Engineers Comments Regarding Surface Water Drainage

Application Reference:	AL/6/25/DOC	Reviewer Reference:	ADC/EXT4
Planning Officer:	Hannah Kersley	Date of Review:	01/10/2025
Site Name:	8 Autumn Gate Hook Lane Aldingbourne PO20 3TE		
Application Description:	Approval of details reserved by condition imposed under reference AL/75/24/HH relating to condition number 4 - surface water drainage scheme.		
Assessment Number:

Condition 4: **Objection**

Typical BIO Retention Planter Detail
(not to scale)

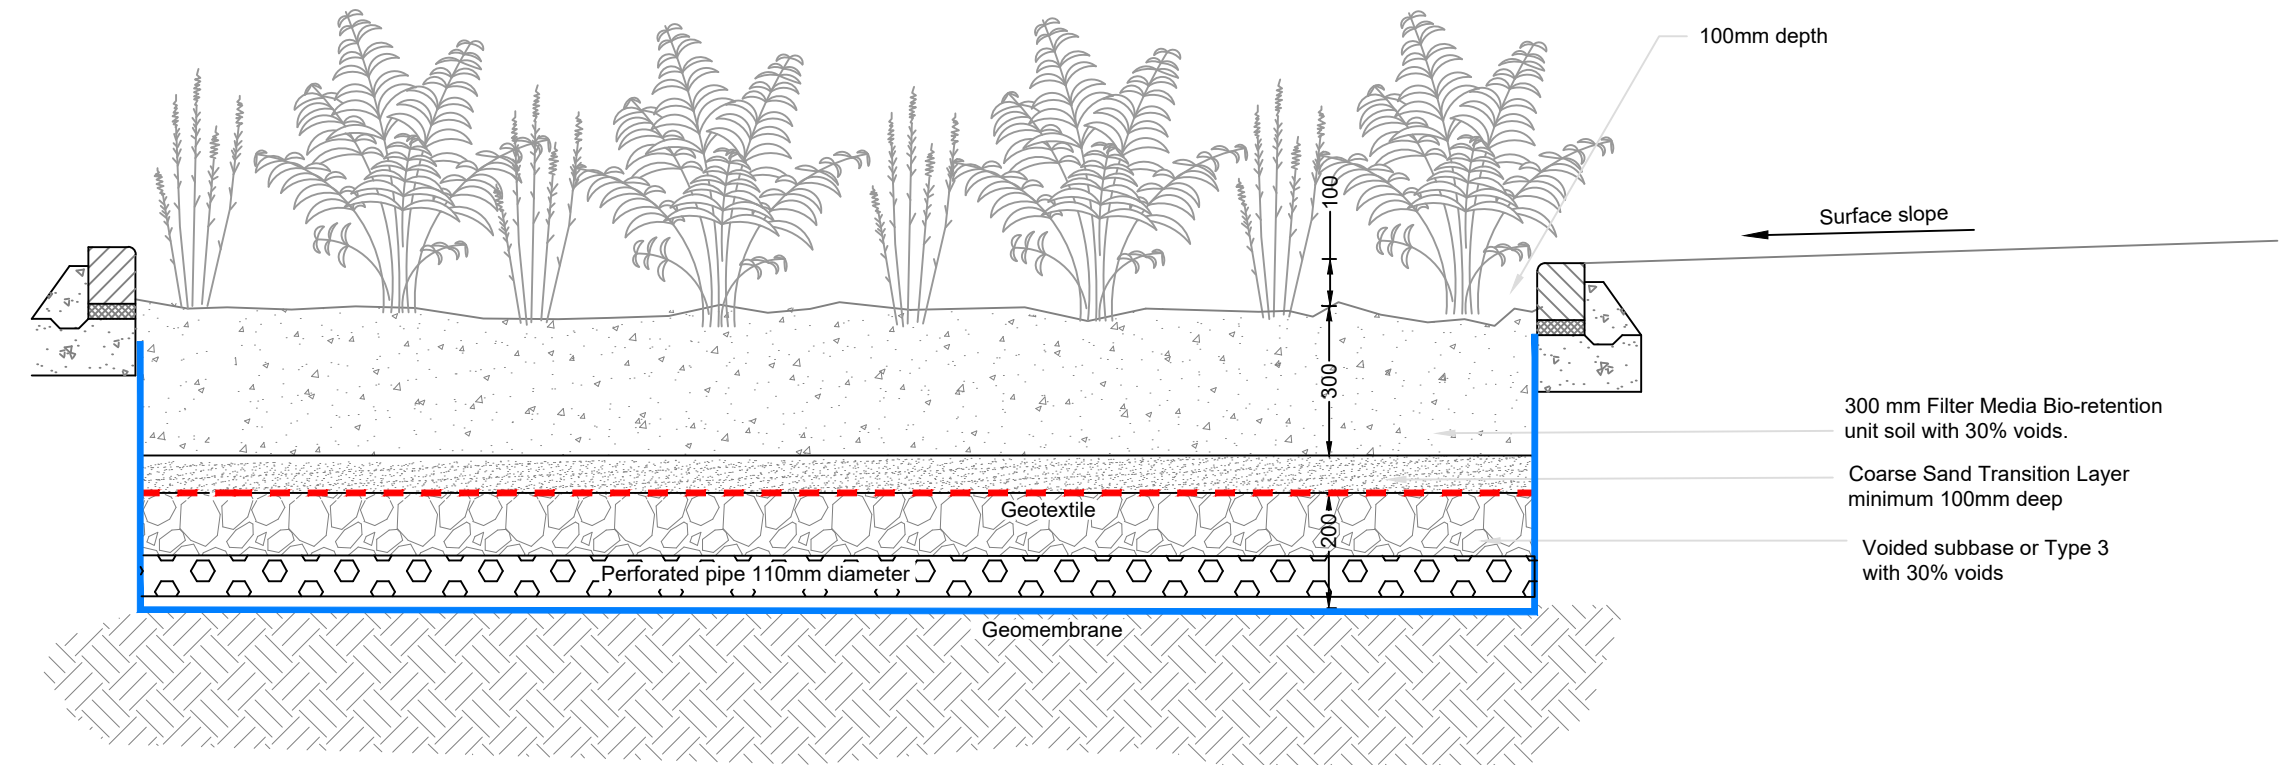
2.	ADC Drainage Response (AL-6-25-DOC) 15/07/2025 Please provide interception drainage to ensure that the first 5mm of rainfall over the proposed impermeable area is not discharged from the site. I.e. rainwater harvesting, etc. Designer response (AL-6-25-DOC) 25/7/2025 A water butt will be provided to capture the first 5mm of rainfall, in line with the interception drainage requirement. ADC Drainage Response (AL-6-25-DOC) 26/08/2025 Water butt proposed to serve part of roof only. However, Standard 2 of the National harvesting, etc. Standards advises that	Noted. The water butt will now be used solely for rainwater reuse and not relied upon for interception. To ensure compliance with Standard 2, we are proposing a lined bioretention planter unit which will capture, convey and store the first 5mm of rainfall, allowing runoff to be naturally absorbed or lost to the atmosphere. The construction detail has been provided-please see Proposed Typical Construction Details Rev. P2	Whilst the use of the bio-retention planter is welcomed, please review the detail. Currently the perforated pipe and inlet to this system is at the base of the planter. As such the initial surface water run-off will miss the benefits of the planter and not provide the level of treatment/interception required. Please consider either raising the inlet level or dropping the finished level of the planter to achieve the full benefit of the raingarden. As a minimum we the inlet should be no deeper than 250mm below the finished level of the planter to achieve the required interception and we would expect a maximum void ratio of 20%

water butts do not achieve the interception requirements, unless they can be demonstrated to comply. Please review. Full construction details will be required to support any proposal.

5.	ADC Drainage Response (AL-6-25-DOC) 15/07/2025 Calculations; a) Apply urban creep to all storm simulations (only applied to 1/100 year event). b) Design against a surcharged outfall. Suggest this level is taken as the top of ditch bank. c) Ensure all storm simulations include winter events	The surcharged outfall has now been designed, and the drainage calculations have been updated to reflect the winter storm. Please see '04.09.25 Storm Water Calculations 0.6l/s' However, due to the required surcharged outfall, the maximum flow discharge rate needs to be increased by 0.1 l/s, resulting in a revised maximum flow discharge rate of 0.6l/s	Please review the calculations and detail for the bio-retention planter. Currently the calculations take benefit of 565mm depth of attenuation medium of 30% void ratio. This appears to over-estimate the available attenuation volume since the planting medium will need a good mixture of loam and sand to sustain plant ground etc... and thus 30% may not be achievable. Please expand on the specification on the construction detail, clearly adding the specification for the planting and filter

Designer response (AL-6-25-DOC) 25/07/2025 The surface water calculations have been updated. • Urban creep of 10% has been applied to 1 in 100 year event. • The water level at the outfall point is 9.921 m during the 1 in 100 year event plus 45% climate change and 10% urban creep. The top level of the ditch bank at the location of the proposed headwall is 10.000 m • All storm simulations include winter events. ADC Drainage Response (AL-6-25-DOC) 26/08/2025 Provide evidence that a surcharged outfall has been modelled. The 1 in 100 year event simulations do not appear to include winter storms?		mediums etc... in addition please clearly annotate the dimensions required for this bio-retention planter
